A38 Derby Junctions
TR010022

**8.94 Applicant's Responses to Information
or Submissions Received by Deadline 9**

**Applicant's Responses to Information or Submissions
Received by Deadline 9**

Regulation Number	Rule 8(1)(k)
Planning Inspectorate Scheme Reference	TR010022
Document Reference	TR010022/APP/8.94
Author	A38 Derby Junctions Project Team, Highways England

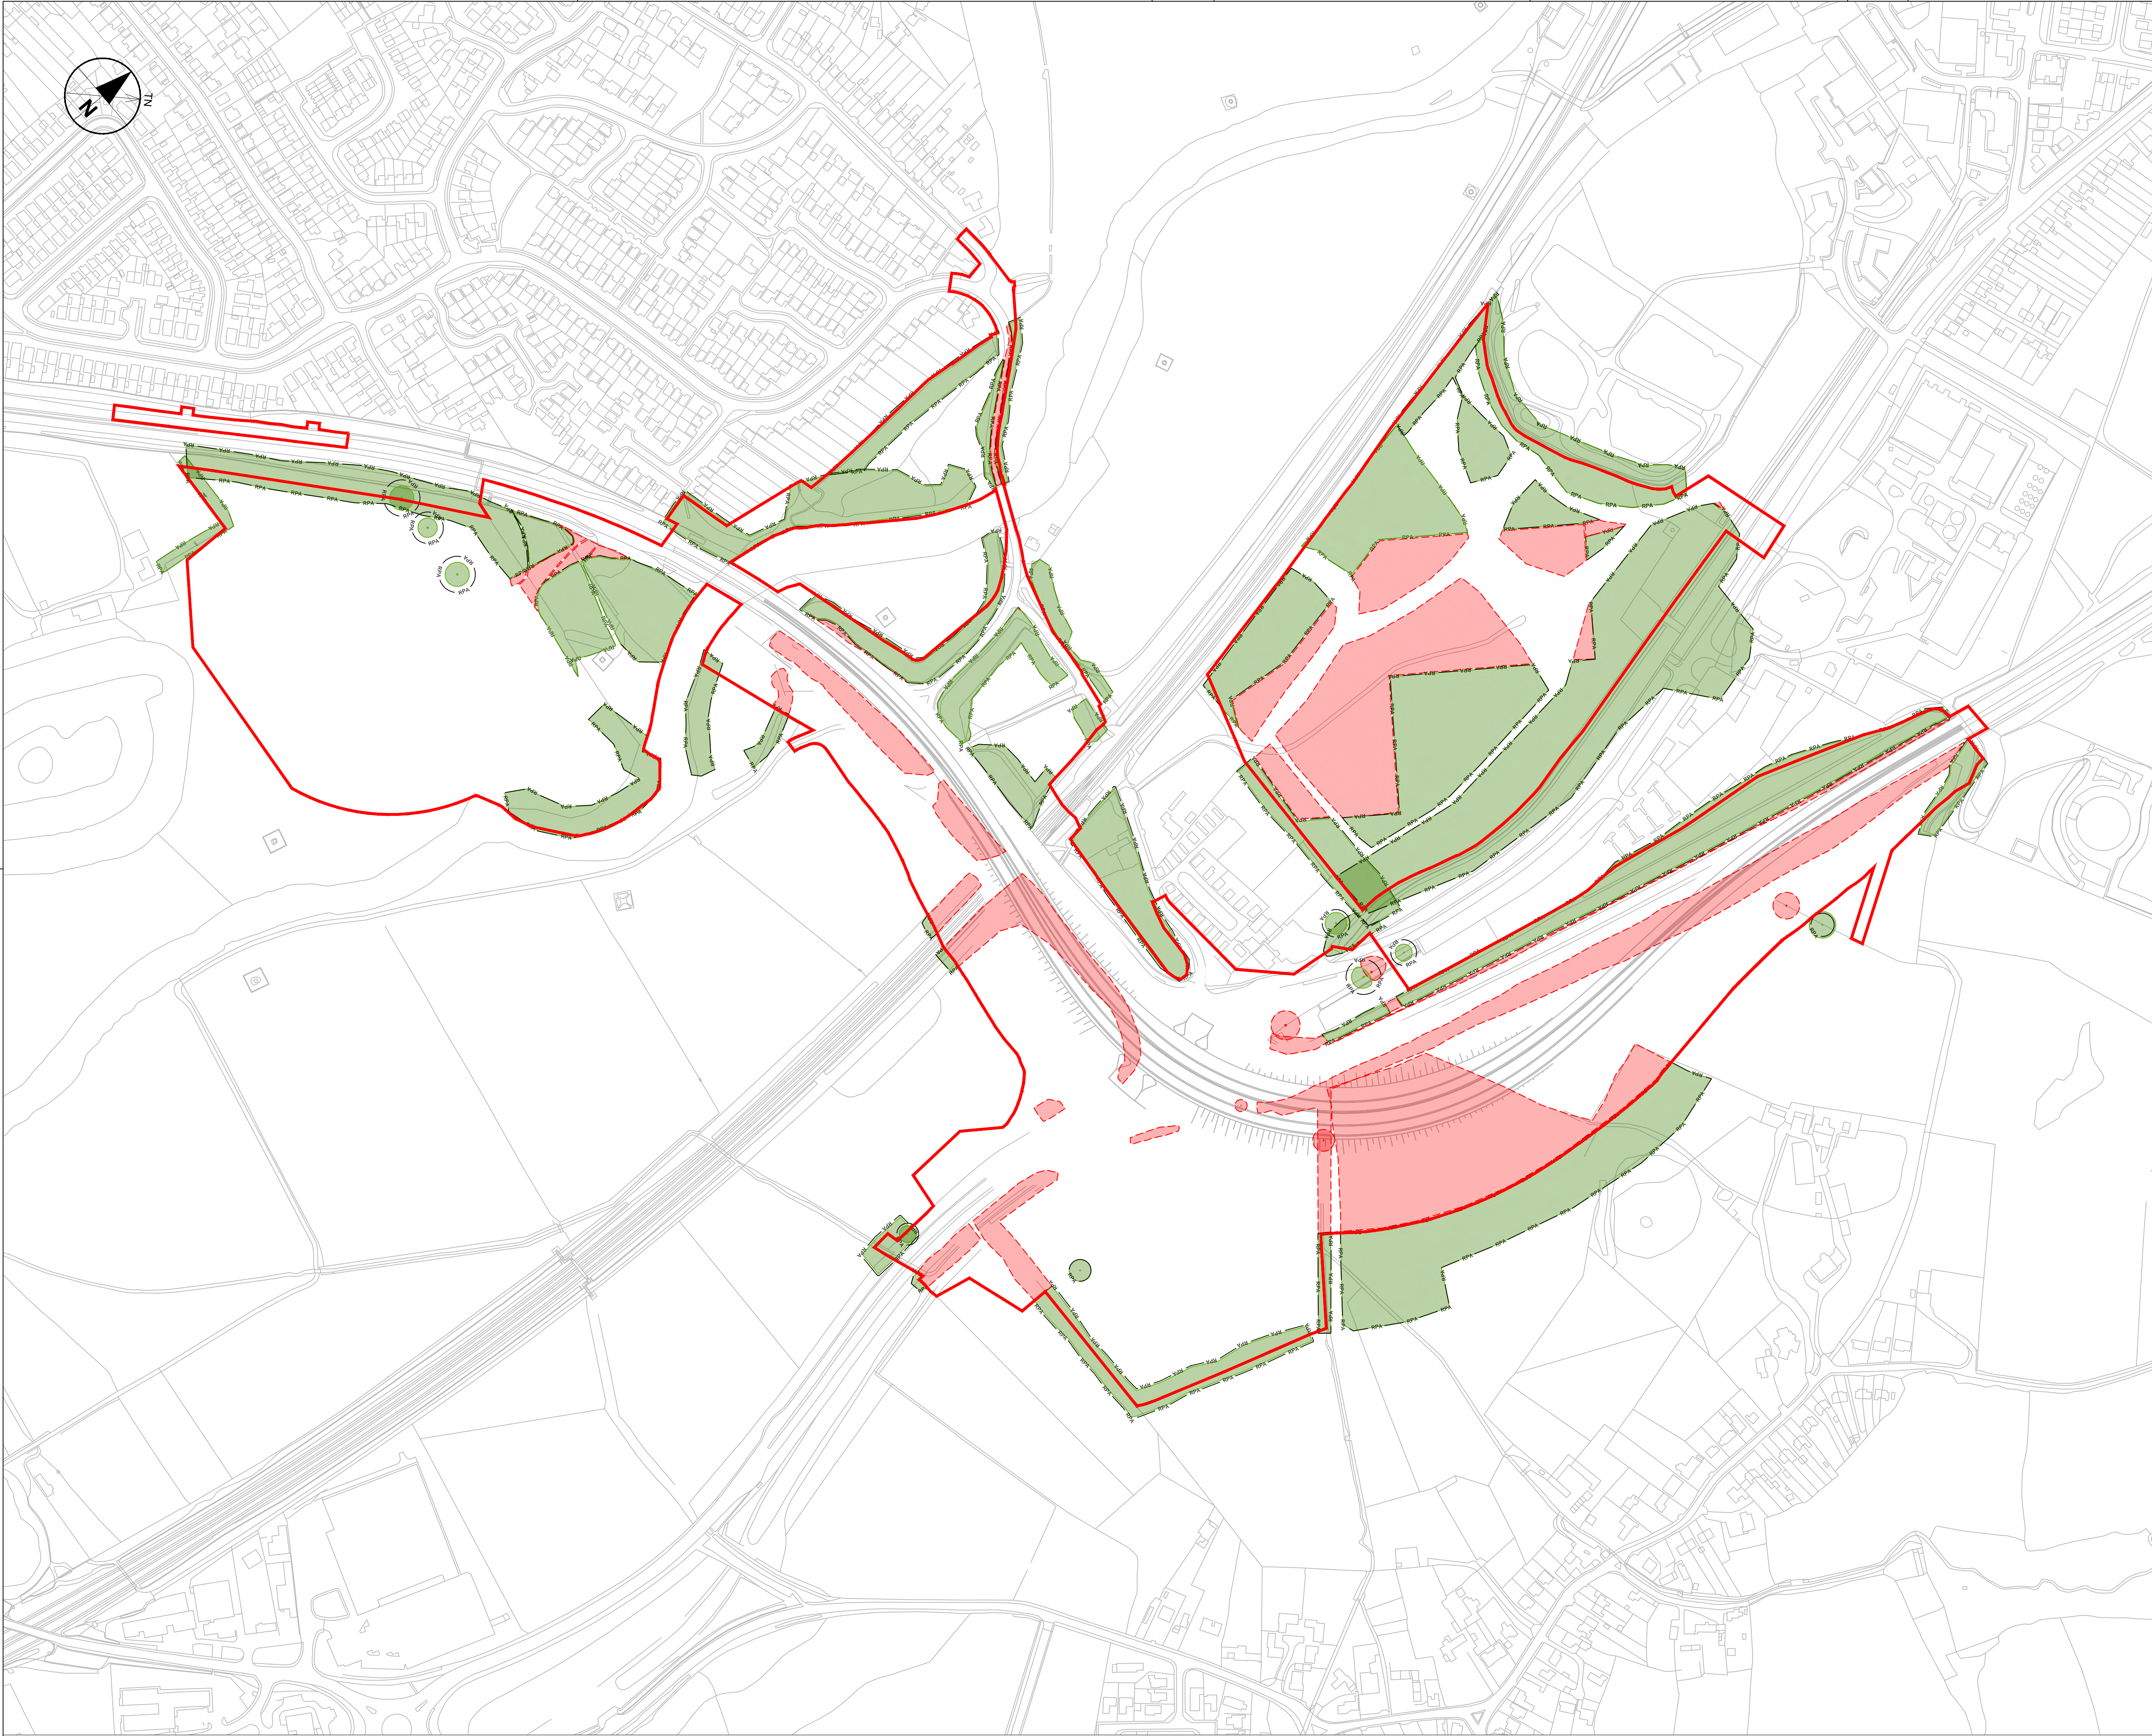
7.6	<p>Q55 HE response regarding air quality in the park being maintained once the trees are gone, is illogical, as the trees/scrub/hedges form a barrier to the current pollution, which, when destroyed, will mean that air quality in the park will be worsened. Does HE agree that the current tree cover/hedgerows/copses forms an air cleaning function, for vehicular air pollution?</p>	<p>At a national level across the UK, trees are important in removing air pollutants but at a local level, the removal of pollution by deposition and subsequent decrease in concentrations is small.</p> <p>During the development of the Scheme's design, HE has sought to minimise the loss of existing trees, include trees in Markeaton Park. Trees are being retained that will</p>

Ref	Comment	Applicant's Response
		<p>maintain the tree buffer between the new A38 and the park (refer to ES Figure 7.6A [APP-092]). With regard to replacement tree planting in Markeaton Park, HE will deliver a landscape design that results in a net increase in trees. During Scheme operation, air quality within the park will achieve the applicable air quality objectives set to protect human health. No significant changes in air quality are, therefore, expected.</p>
